Stormwater Detention and Infiltration Design Data Sheet

SDI worksheet_v2_redlines.pdf Markup Summary

Stormwater Detention and Infiltration Design Data Sheet

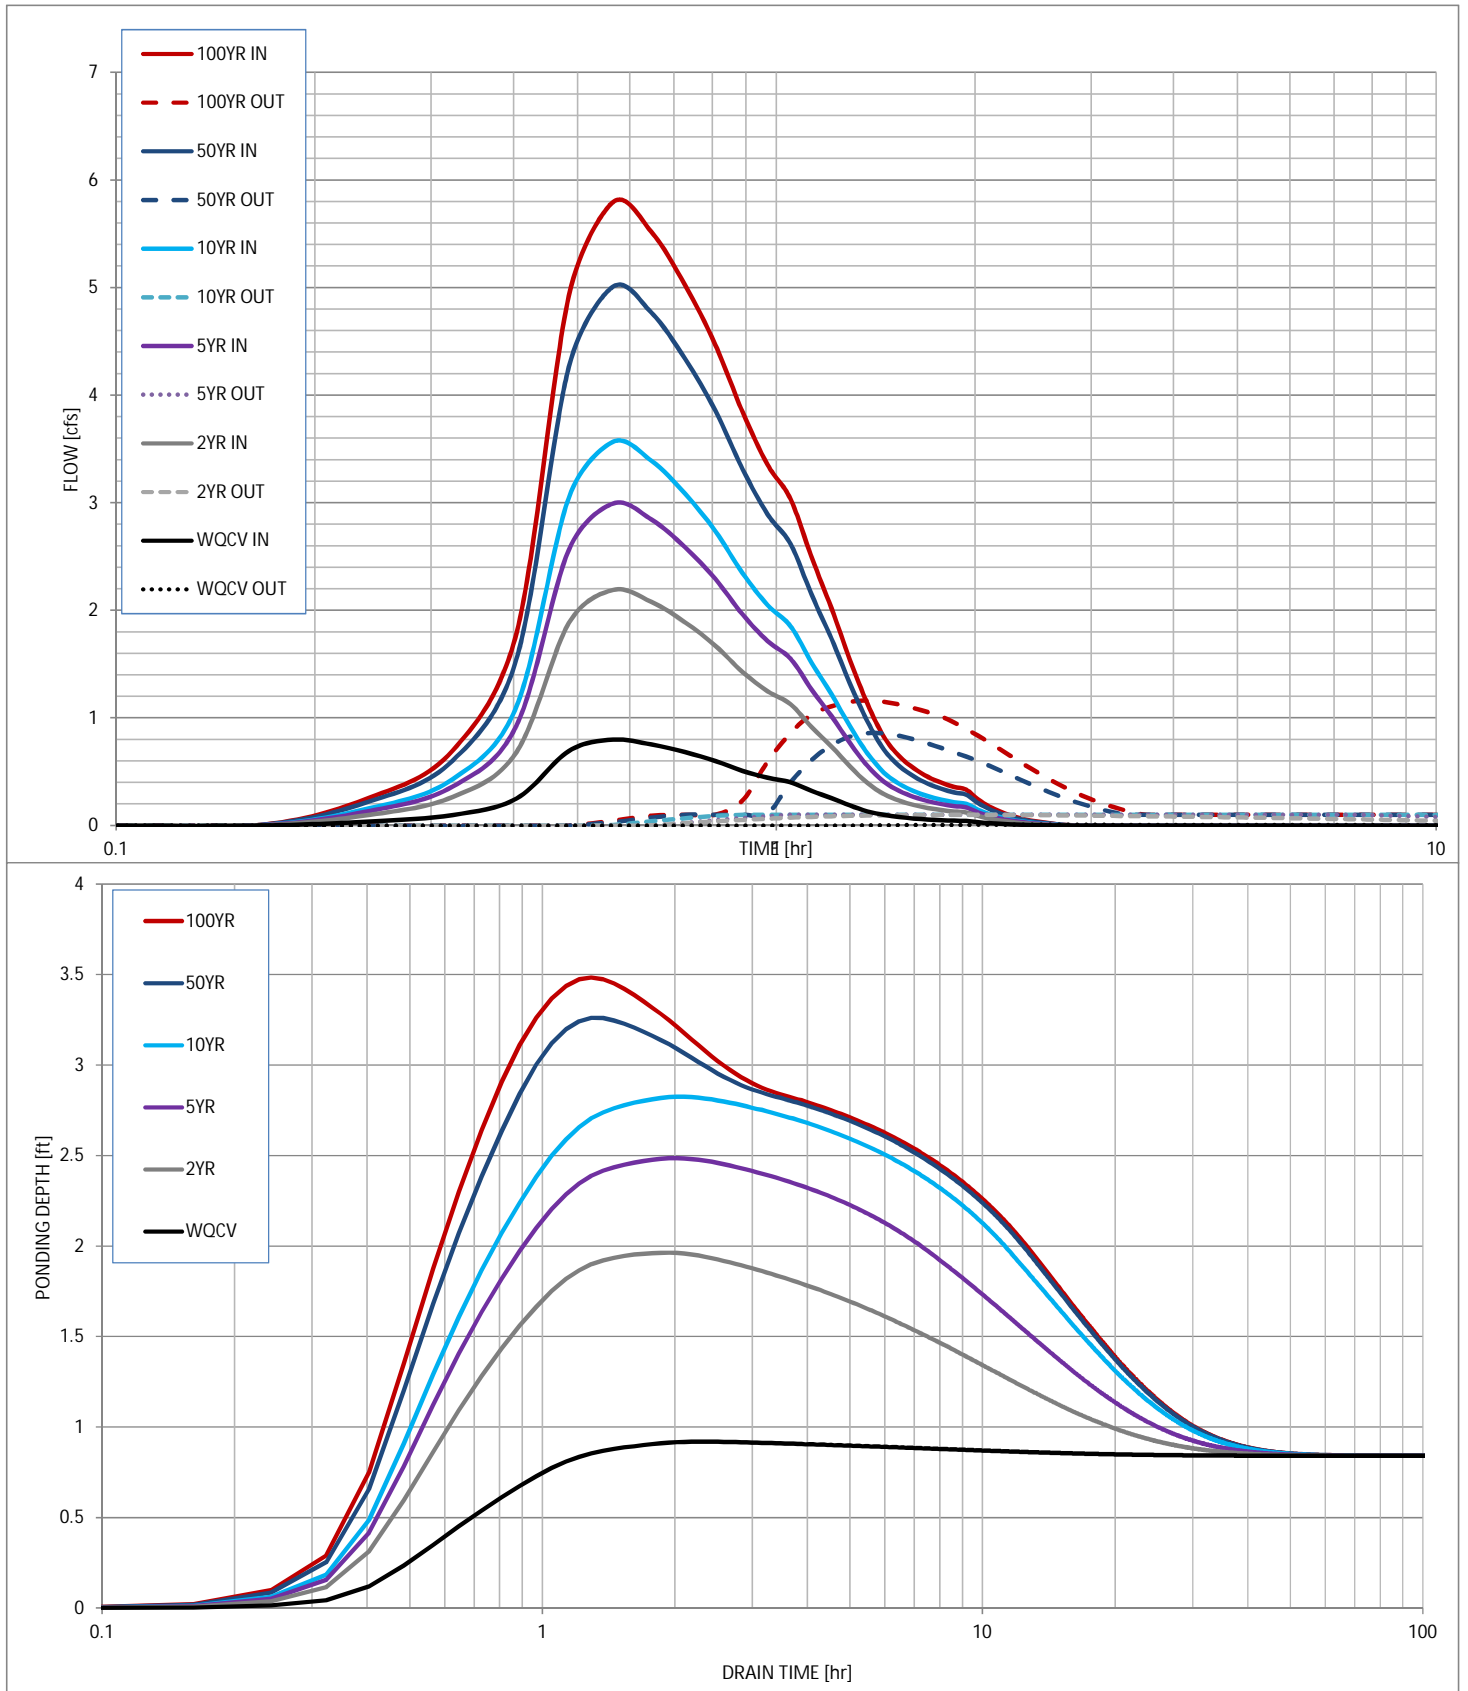
Be advised, this does not meet the senate bill drain time. Also it does not match the design in the drainage report.
